SPACE VILLAGE APARTMENTS: VARIANCE SITE PLAN

VARIANCE
SITE PLAN
V1

Site Plan_V1.pdf Markup Summary

VARIANCE SITE PLAN
V1

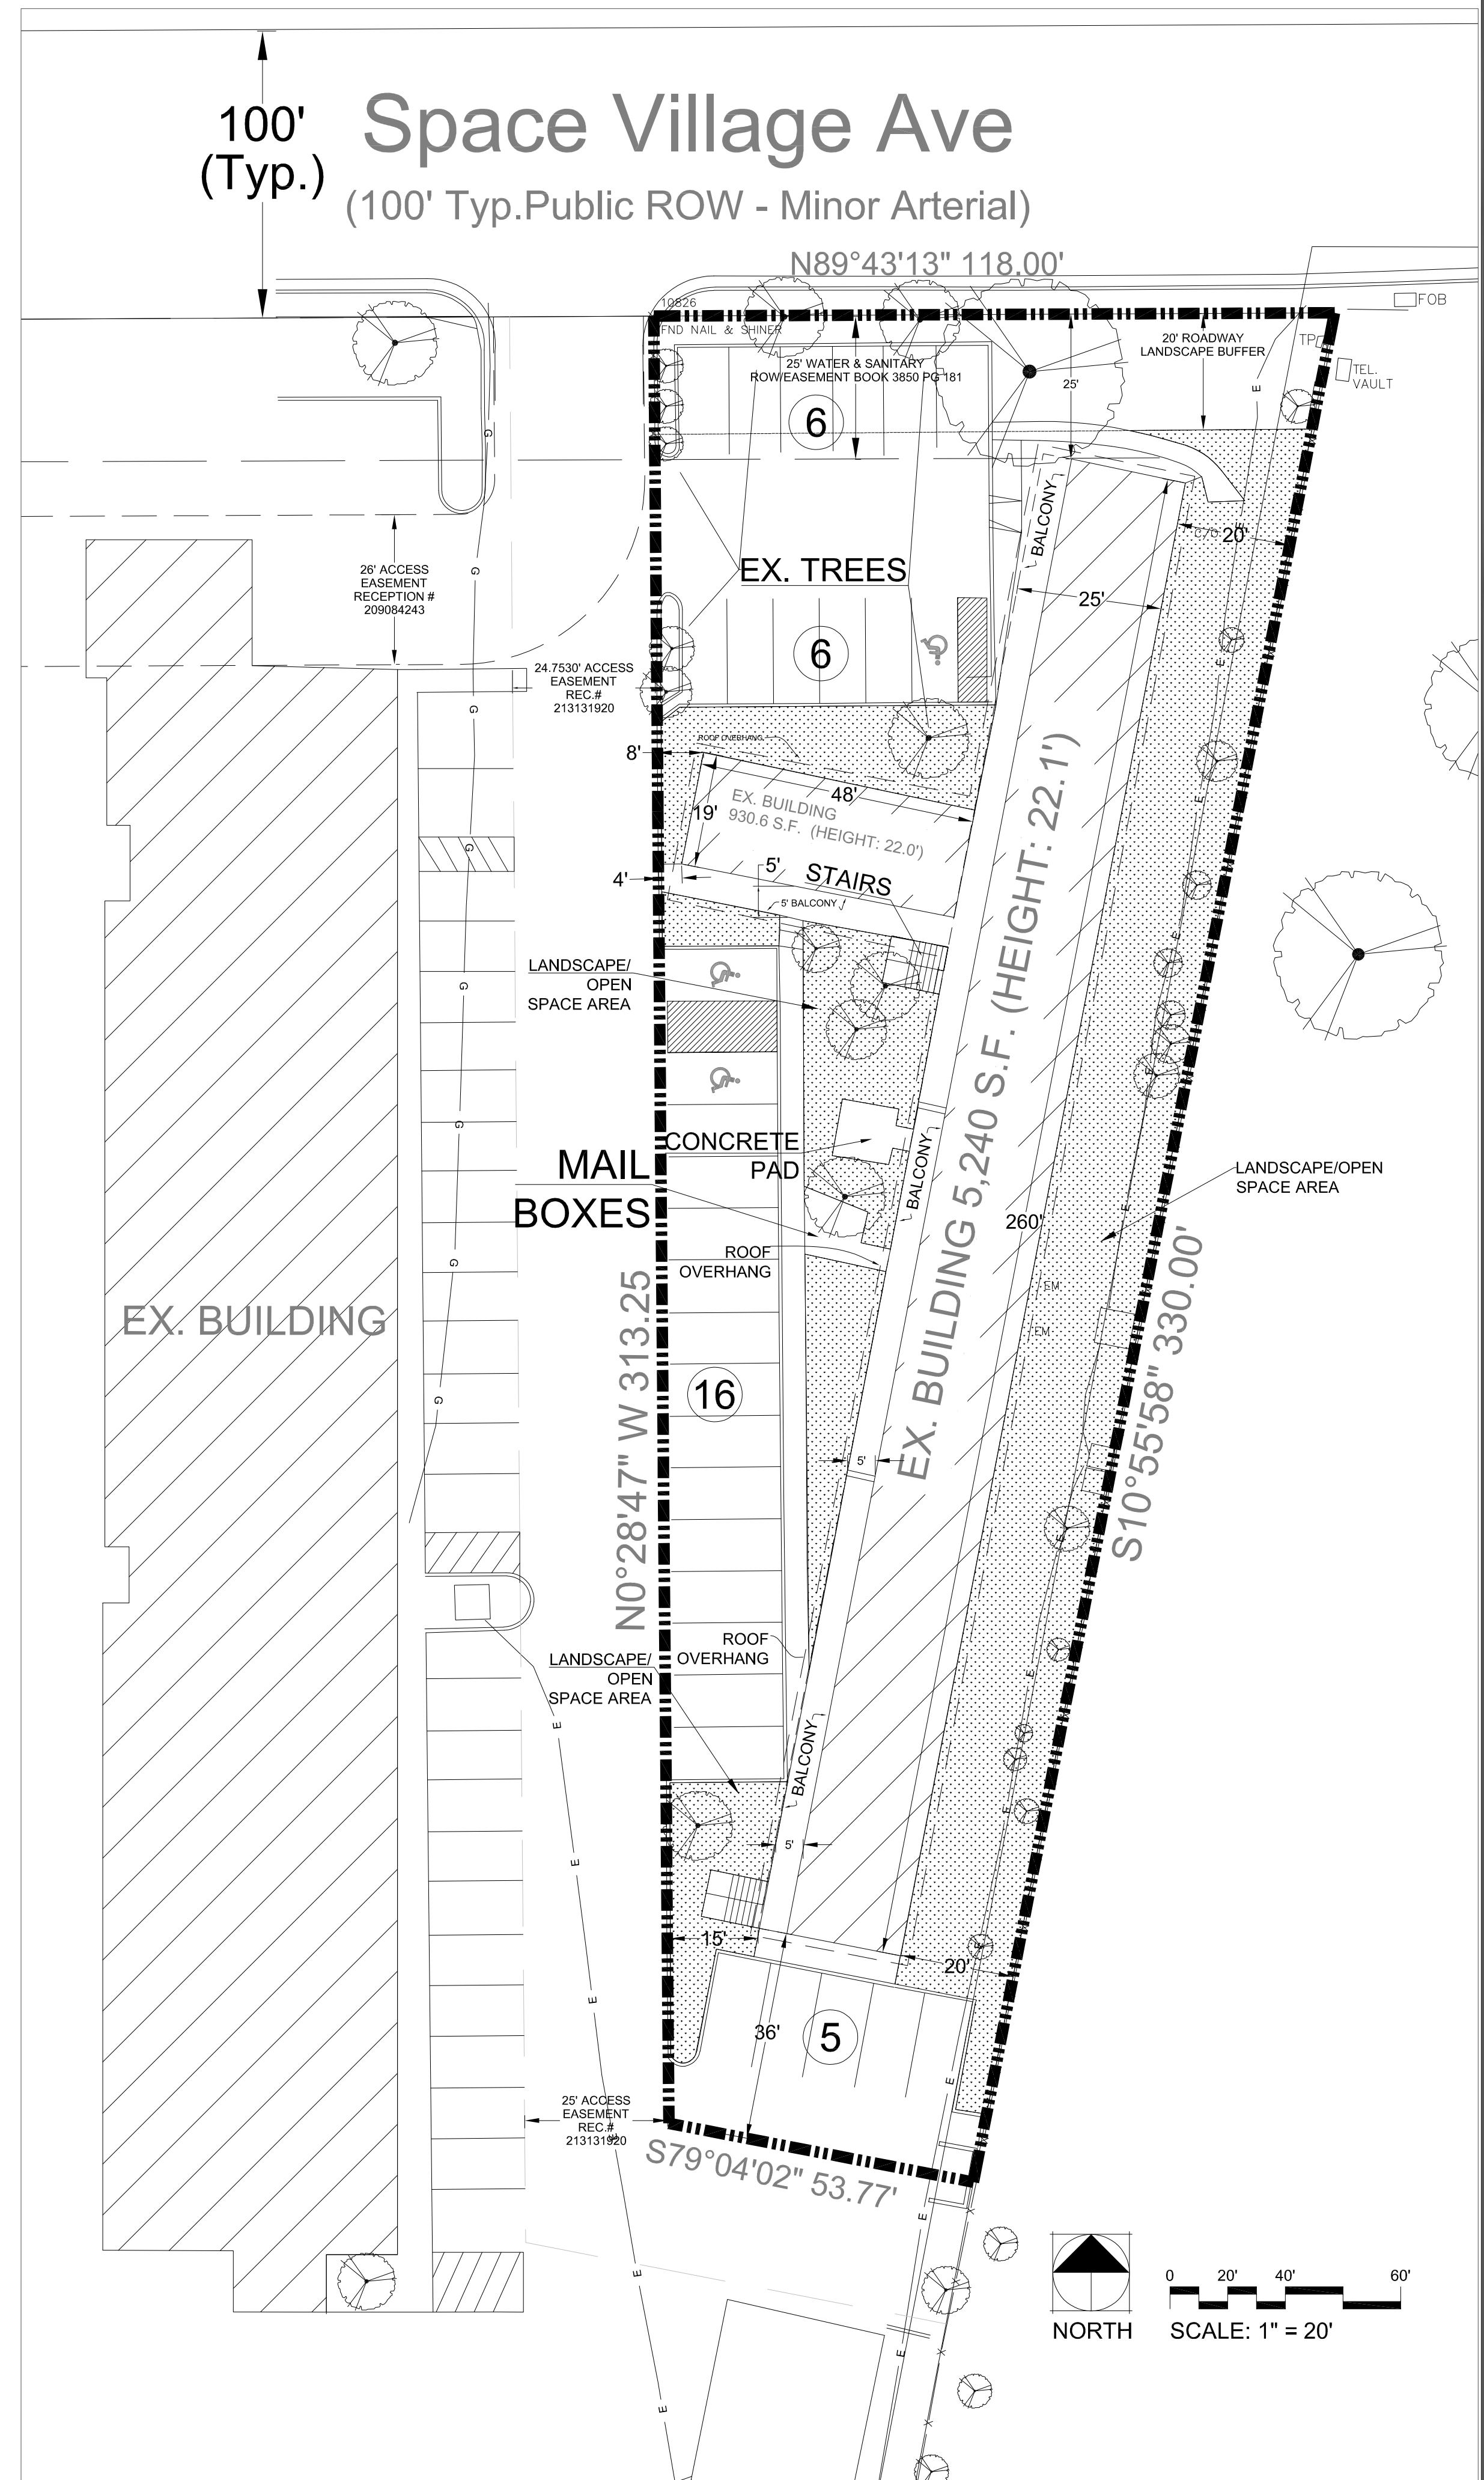
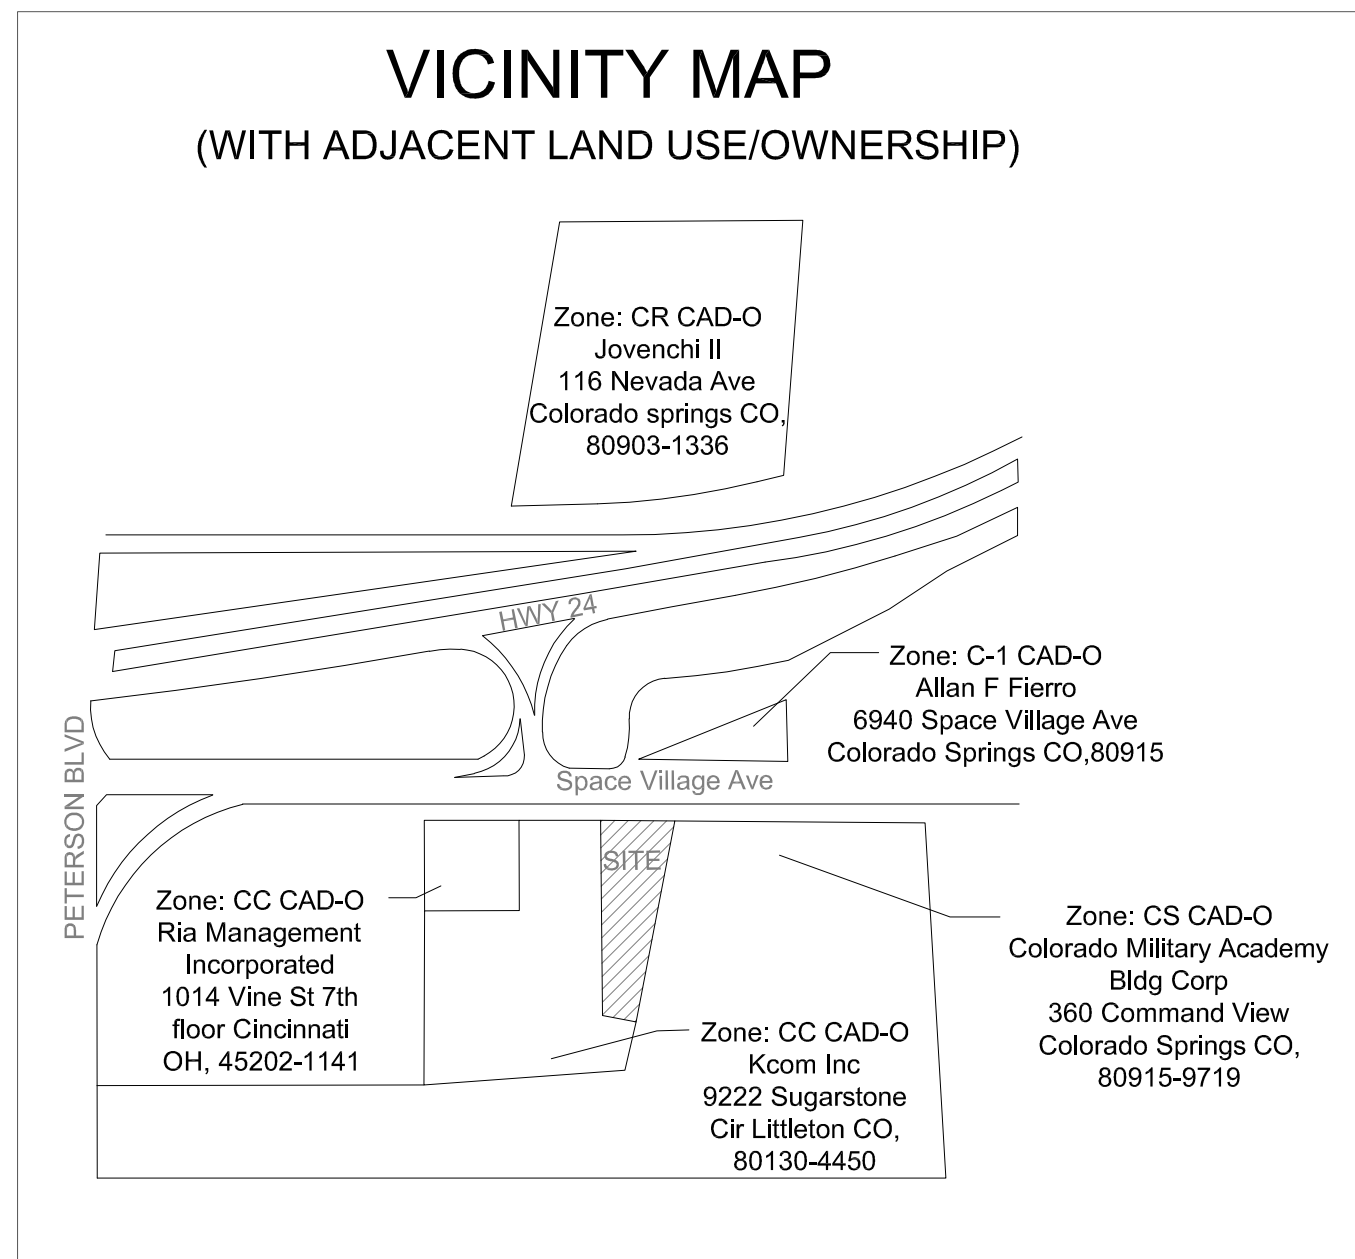
Missing text: Thence North 89 Degrees 42 minutes 7 seconds East,

Please update the ROW width of Space Village.
Per the County GIS the ROW is approximately 100 ft. wide.

FYI: Sidewalk along the property frontage will be required with the final plat/site development plan application.

see enumerations comment about address

Only from a perimeter boundary of the district. No minimum setbacks from internal side and rear within the same district

BOA required

Add PCD File No. VA201
